Our ref: AC/2021/130634/02-L01
Your ref: TR010044
Date: 14 January 2022

A428 BLACK CAT TO CAXTON GIBBET ROAD IMPROVEMENT SCHEME THE EXAMINING AUTHORITY'S 3RD WRITTEN QUESTIONS

Thank you for your correspondence regarding the above mentioned scheme. Our answer to your questions are provided below.

## Appendix B – Soil Storage & Compound Flood Zone drawings

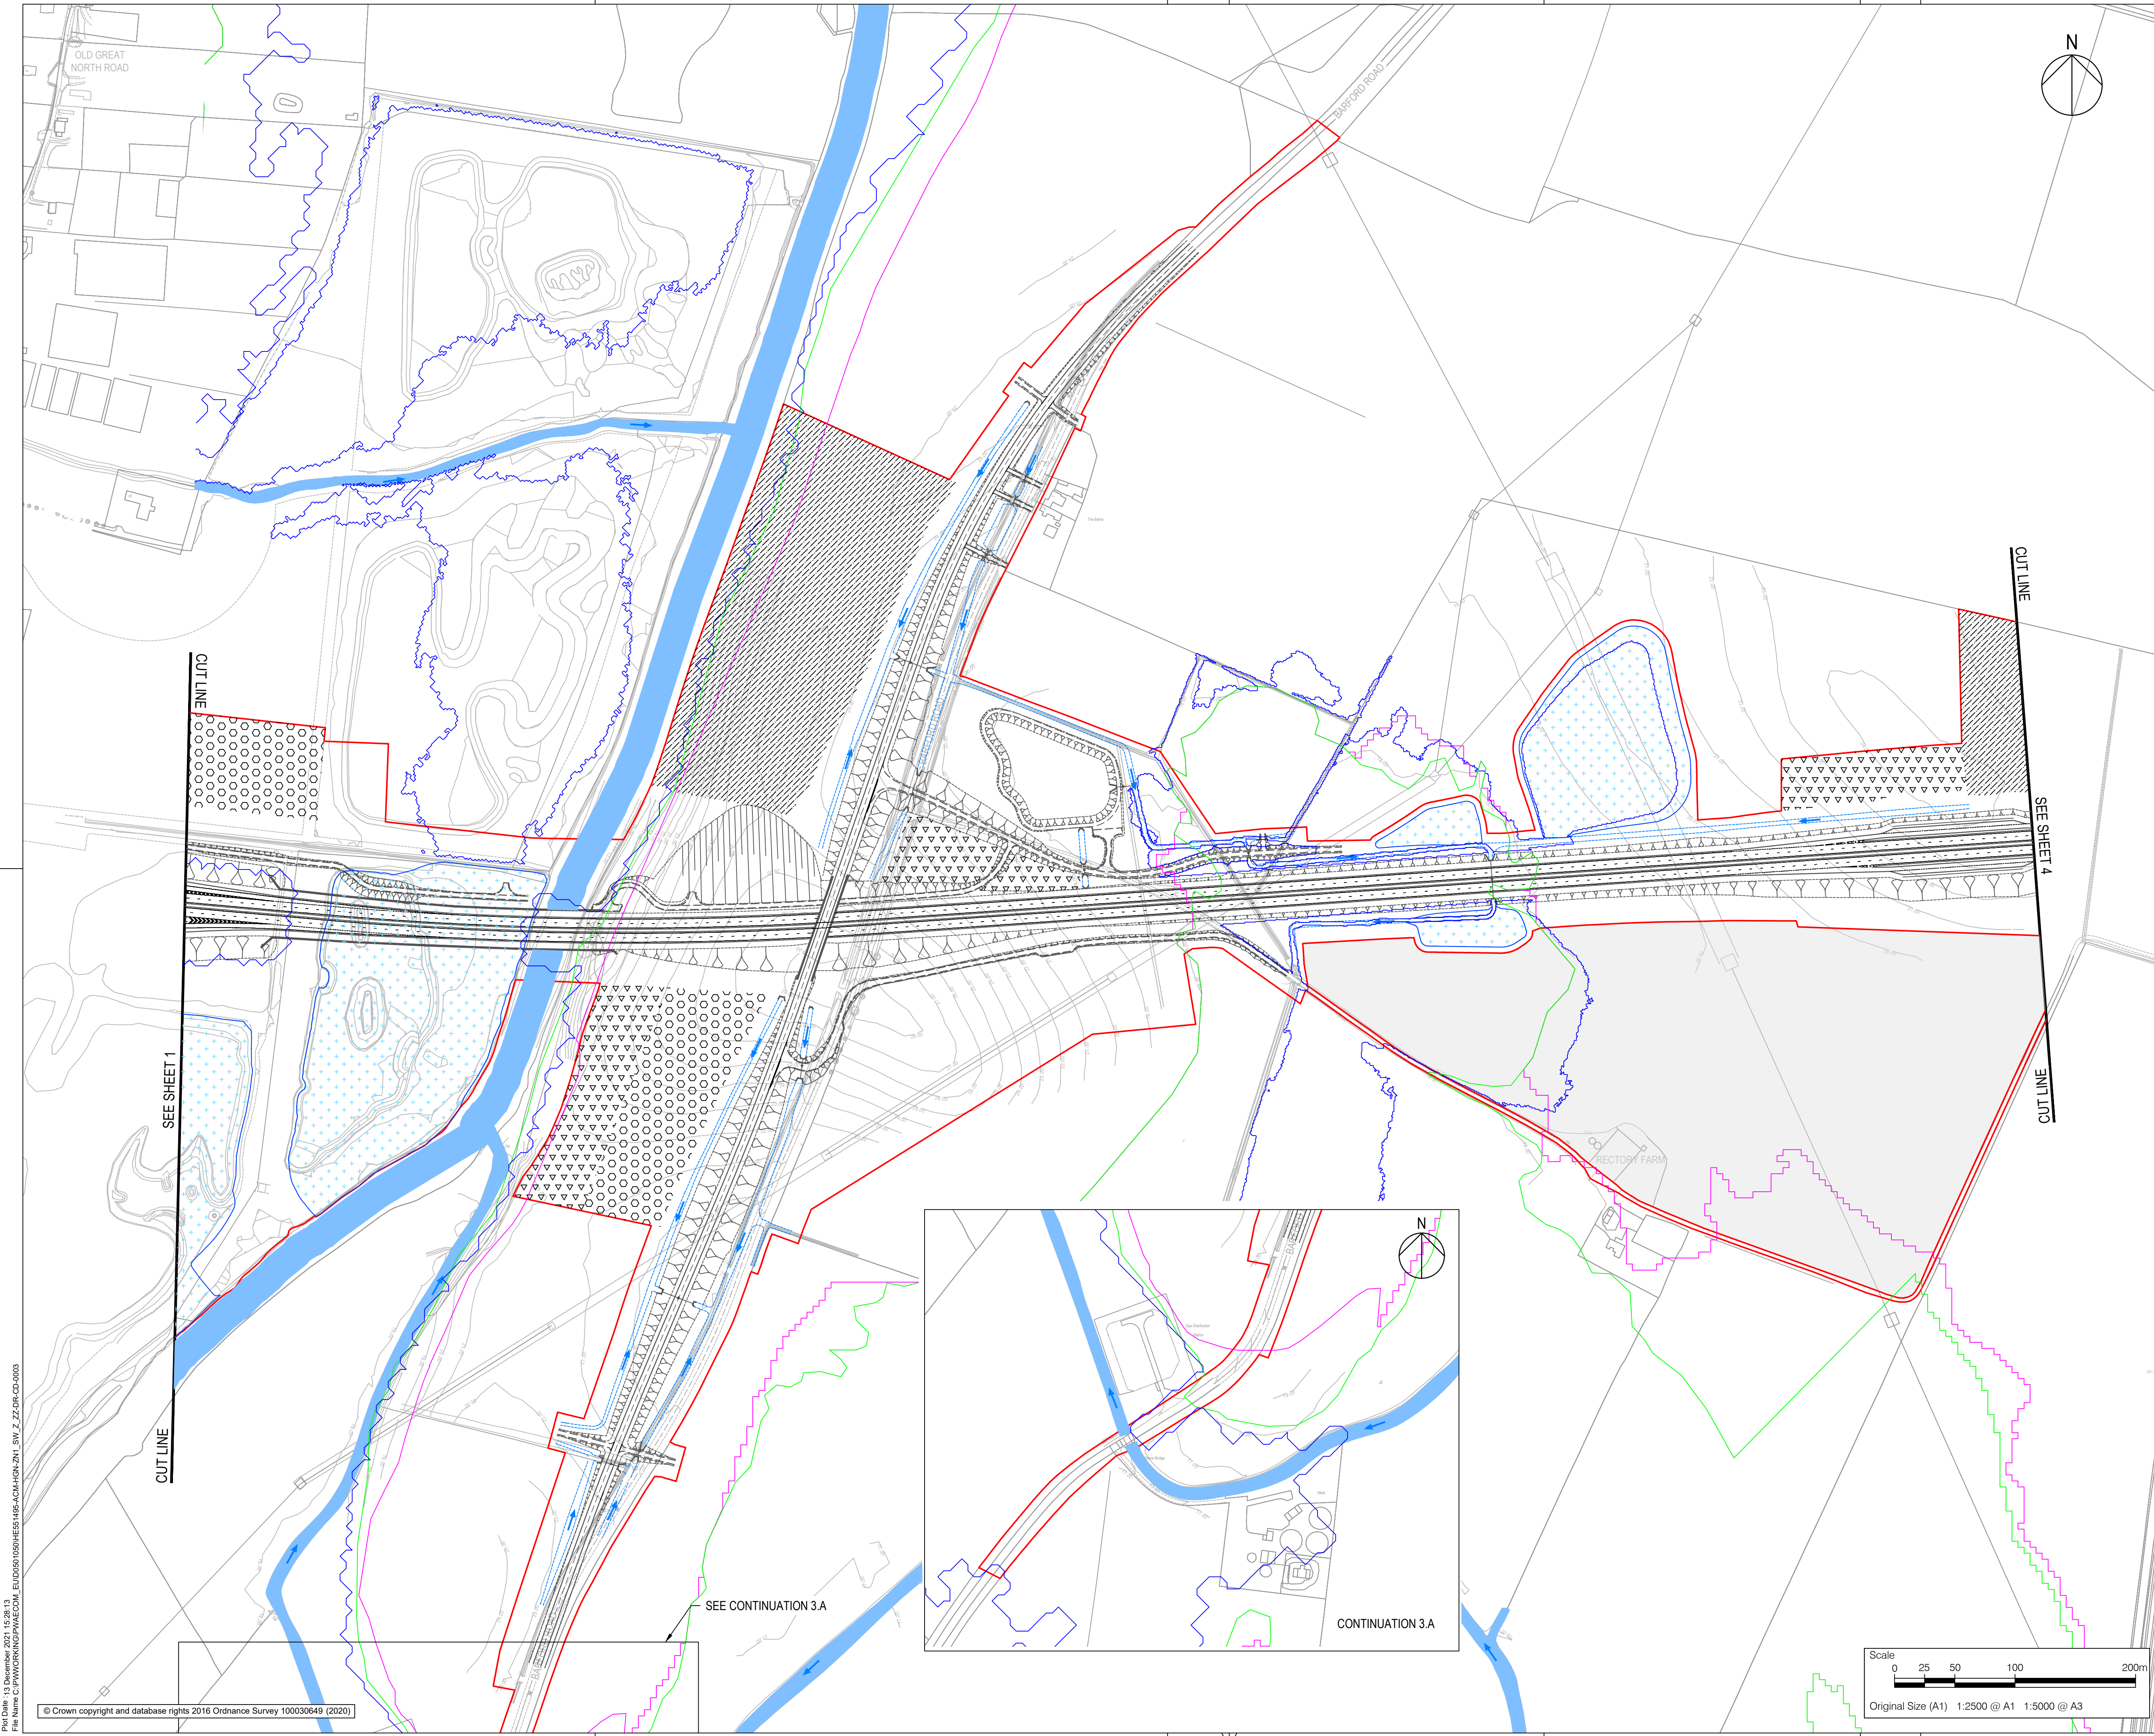
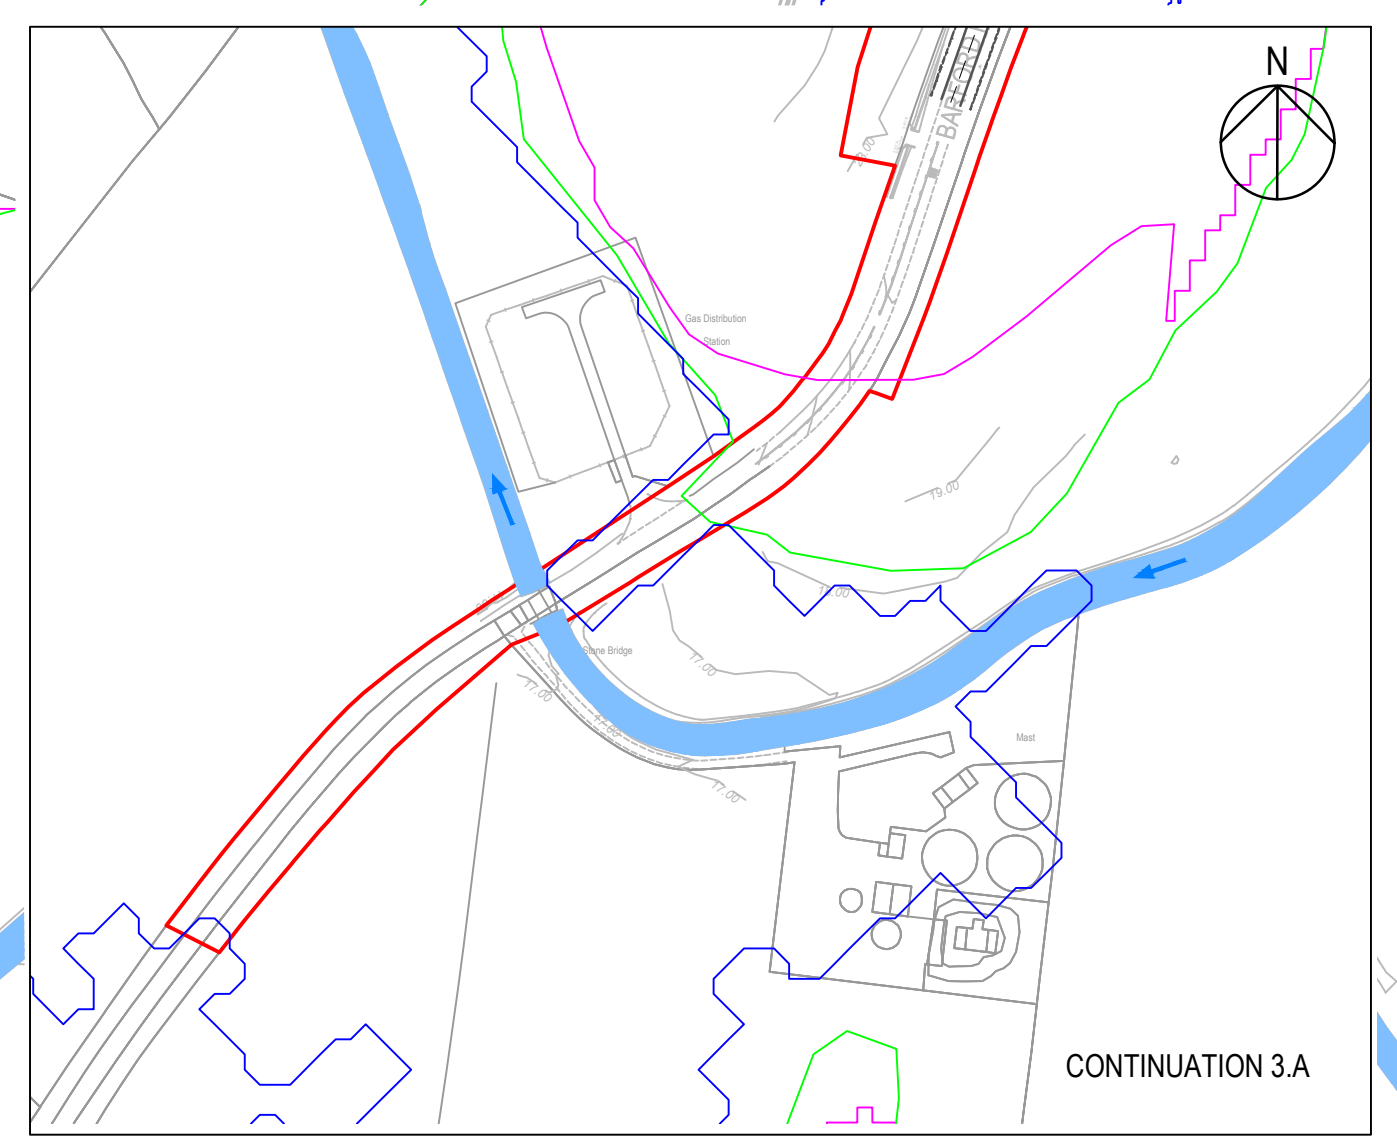
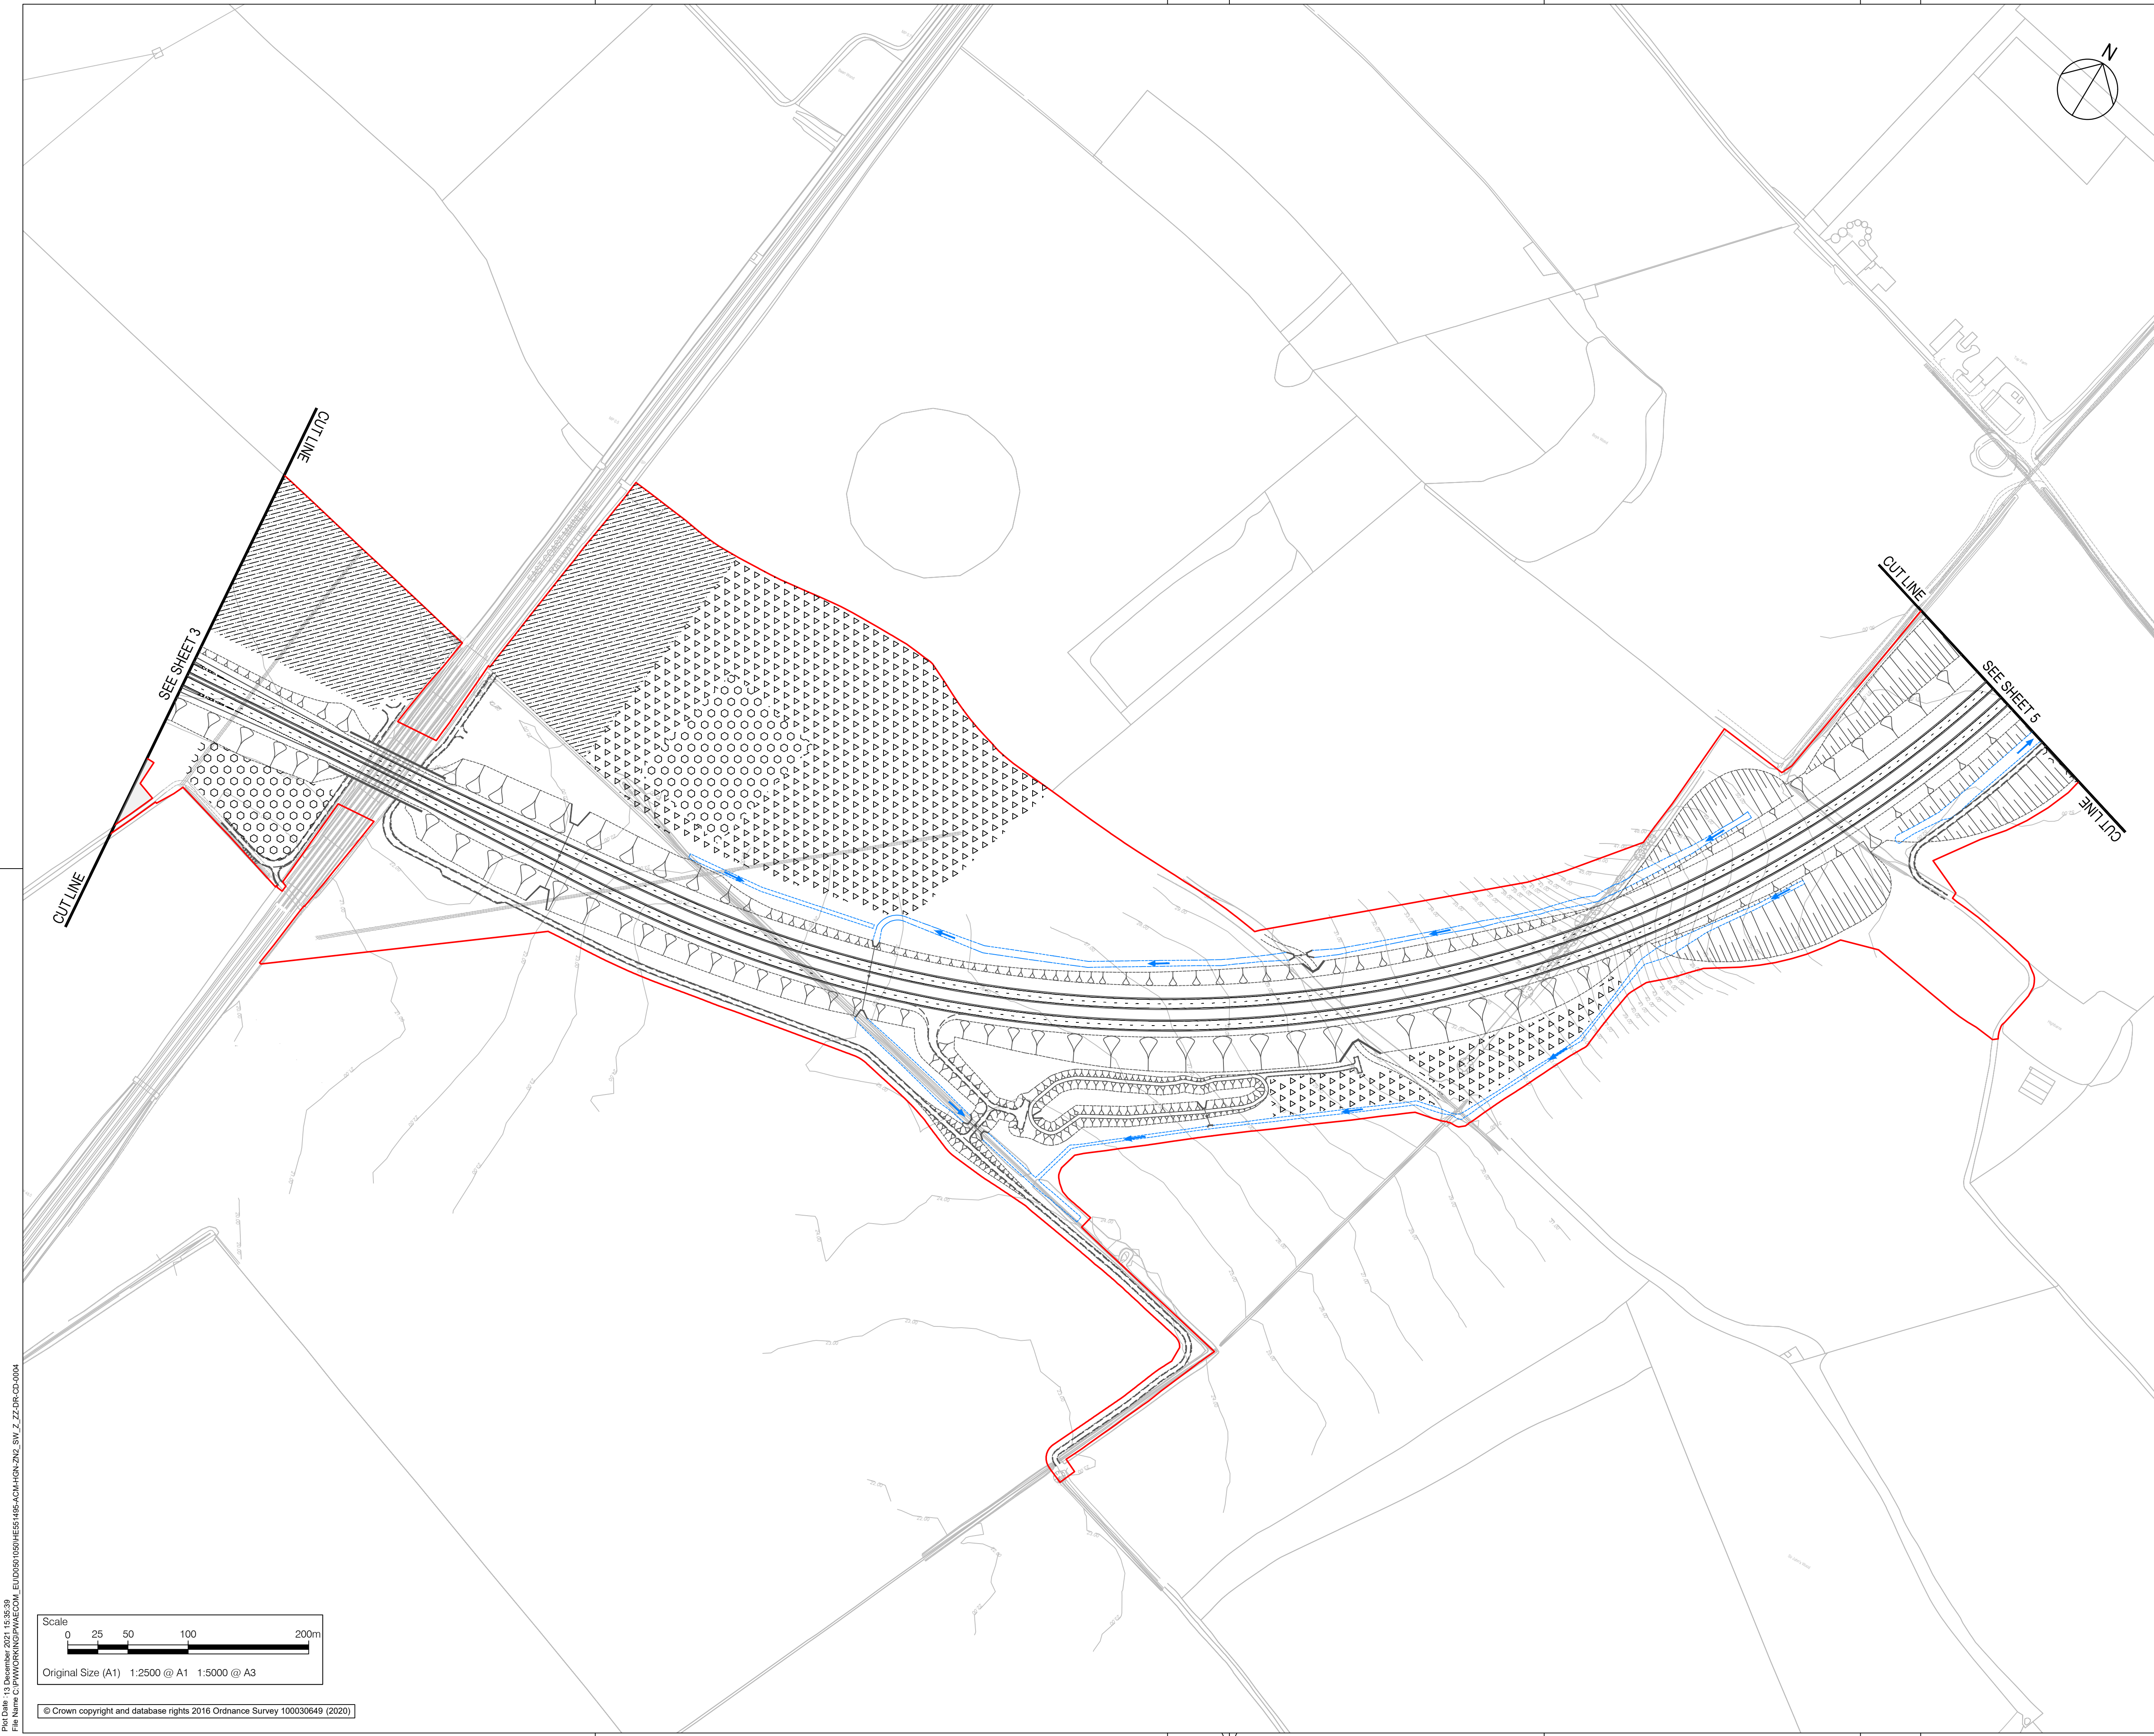
Given that one of the site compound areas is shown to be located entirely within Flood Zone 3 in Appendix B of the FRA Technical Note dated December 2021, we would like the First Iteration EMP to include some mitigation measures in relation to this to ensure there is no increase in flood risk elsewhere during the construction phase.

The First Iteration EMP (sections 1.737, 1.738, 4.2.28 and 4.2.29) states that no hazardous materials (COSHH) will be located in Flood Zone 3 (area at highest risk). However, Appendix B of the Flood Risk Assessment (FRA) Technical Note dated December 2021 still shows a number of site compound and soil storage areas within Flood Zone 3 and some of these are immediately adjacent to watercourses where we would expect flood water to regularly flow and be stored. We therefore consider that no soil storage areas or site compounds should be located within Flood Zone 3.
